Planning Application Reference No.: 3/2022/1098

Address of Development: Fir Tree House 51 Downham Road Chatburn Clitheroe BB7 4AU

**1** PROPOSED SITE PLAN  
Scale: 1:200

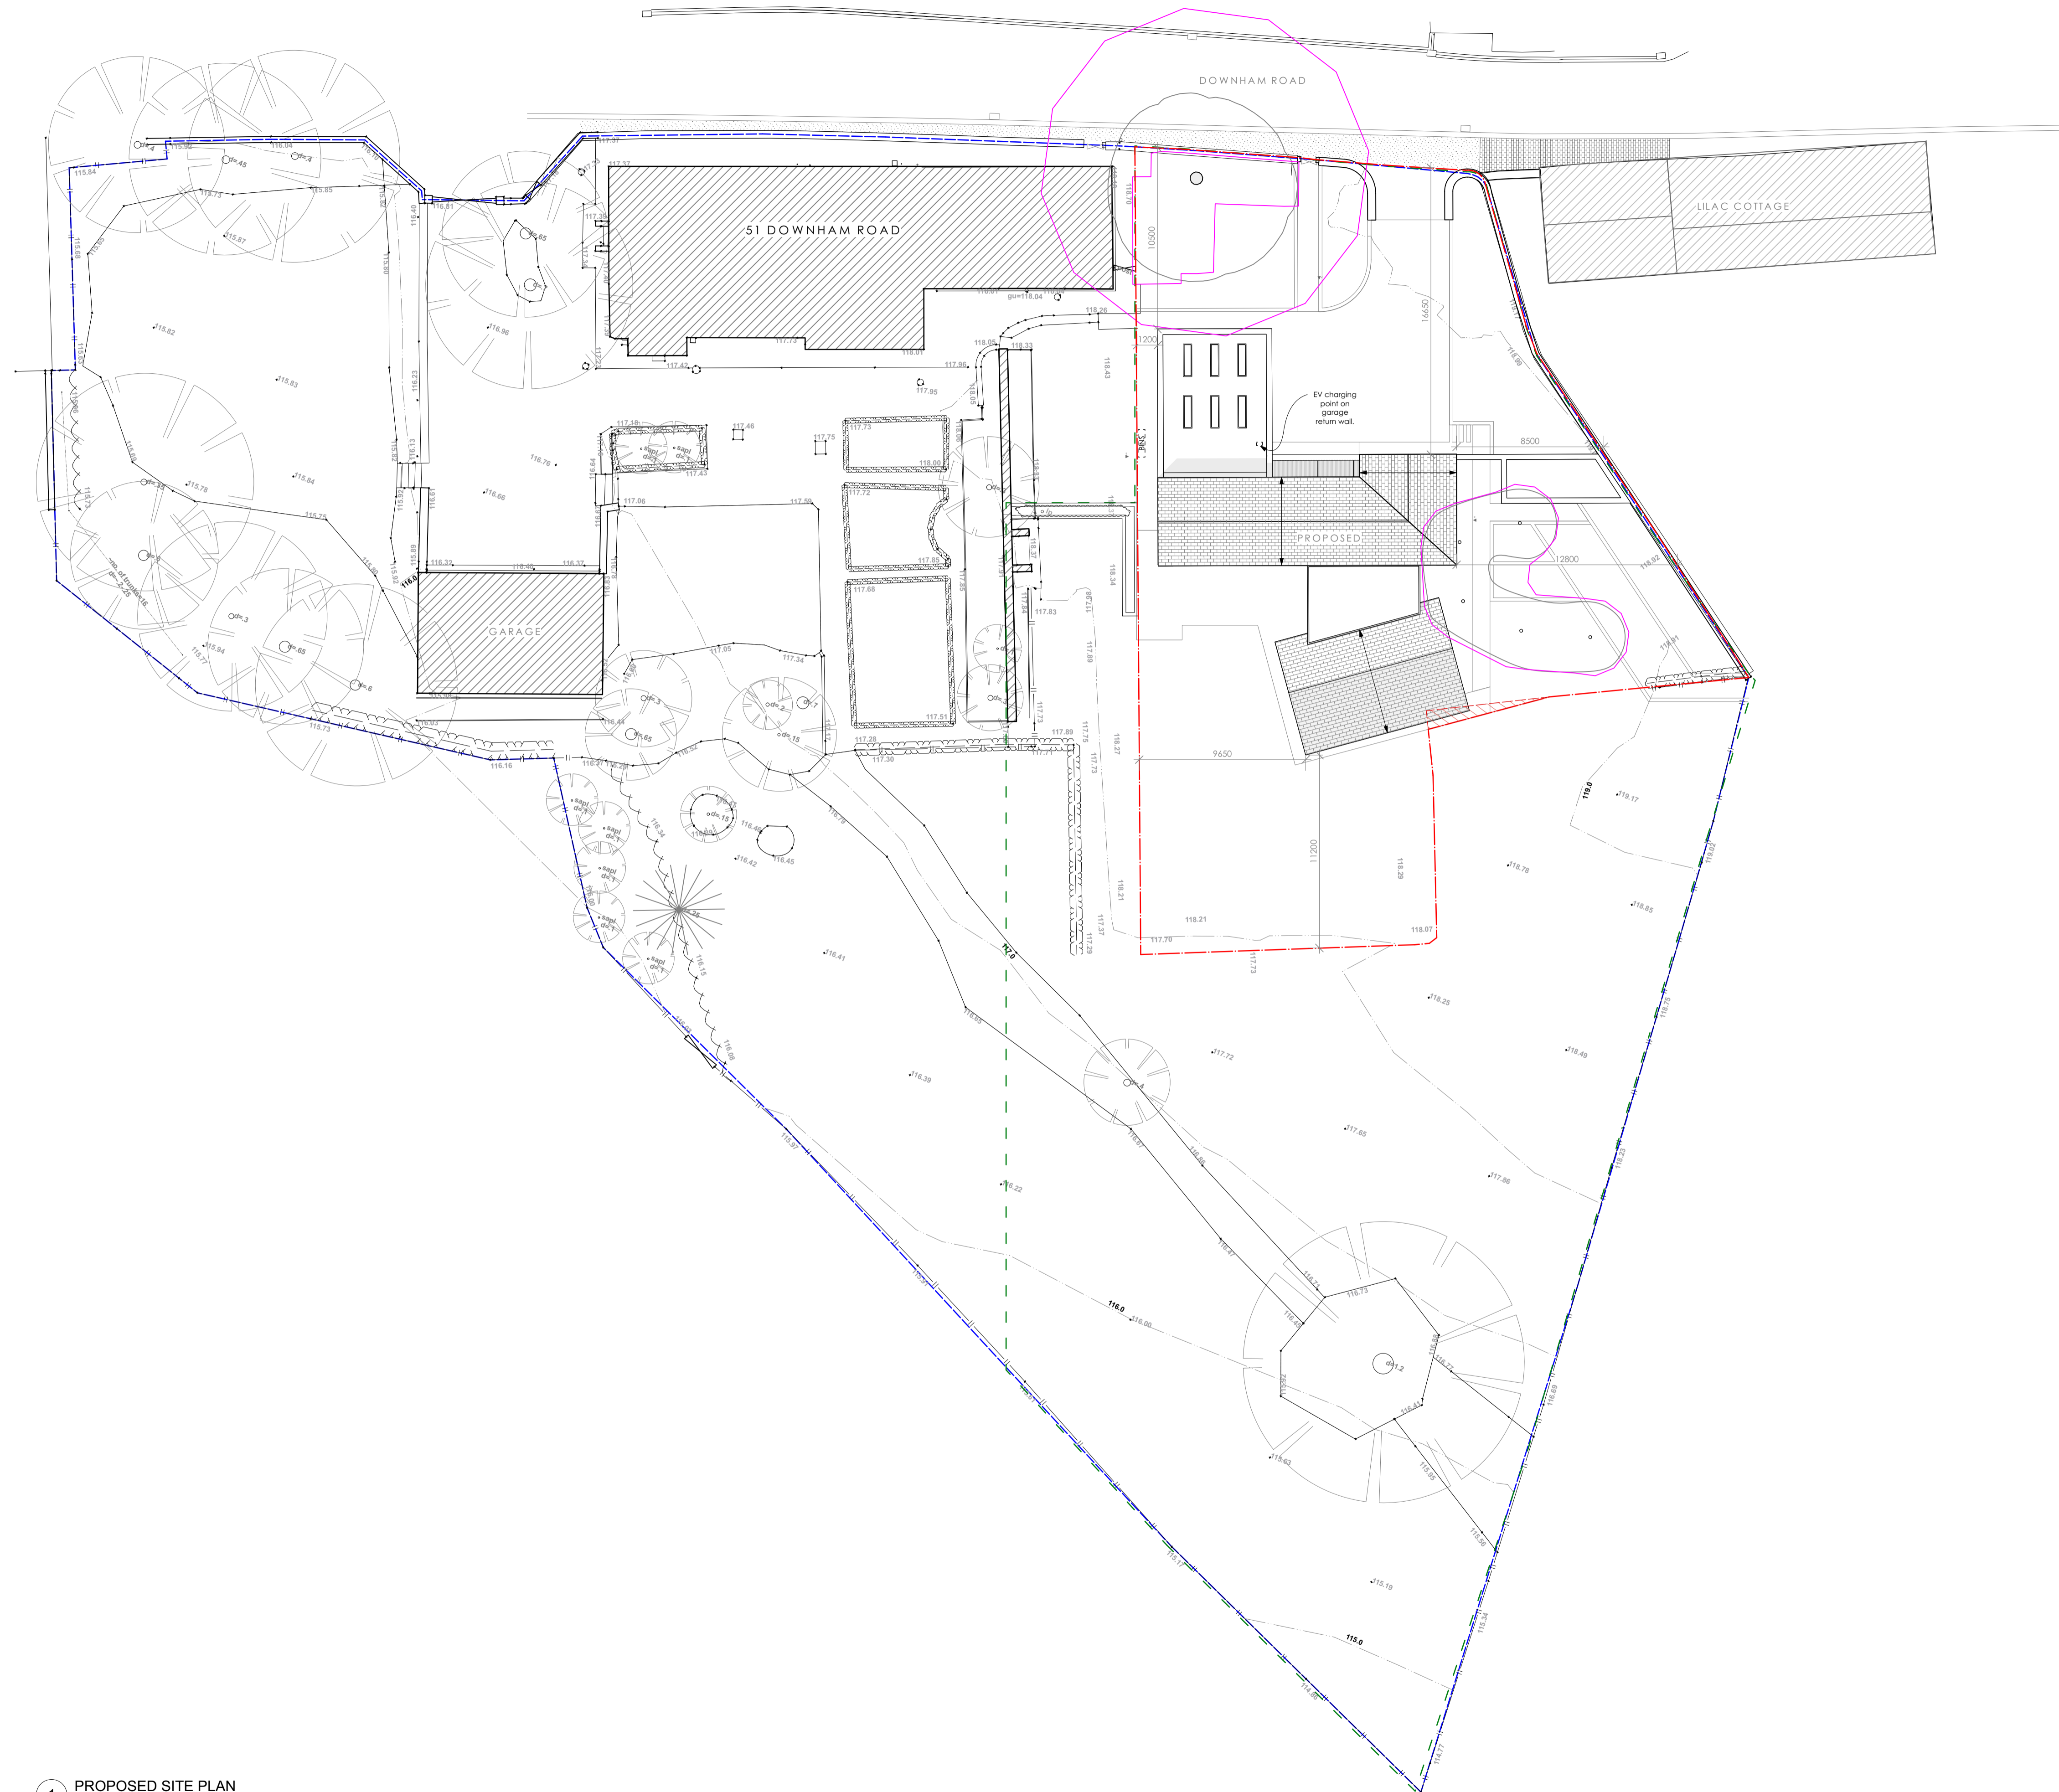
Comments: I object to the vehicular entrance being situated where preposed in this new dwelling. The entrance will be at the very narrowest part of Downham Road and will add further to the congestion that arrises as traffic attempts to pass one another on opposite sides of the narrow road. [REDACTED] has been subject on numerous occasions when [REDACTED]. Further more, traffic almost never travels at the speed limit of 20 miles an hour, there seems to be an assumption by drivers that at the point of reaching the top end of Downham road that the speed limit no longer exists. I believe creating an entrance into the wall as suggested would create a very great safety risk and would ask that a different access to the proposed property should be found, either much further away from the very narrow section of road or via the existing entrance to the main house. I would also like to suggest that a speed limit survey is done prior to any development and that some form of traffic calming is organised on Downham Road especially at the narrowest section. The 20 mile an hour signs are far too small, too few and are not seen.
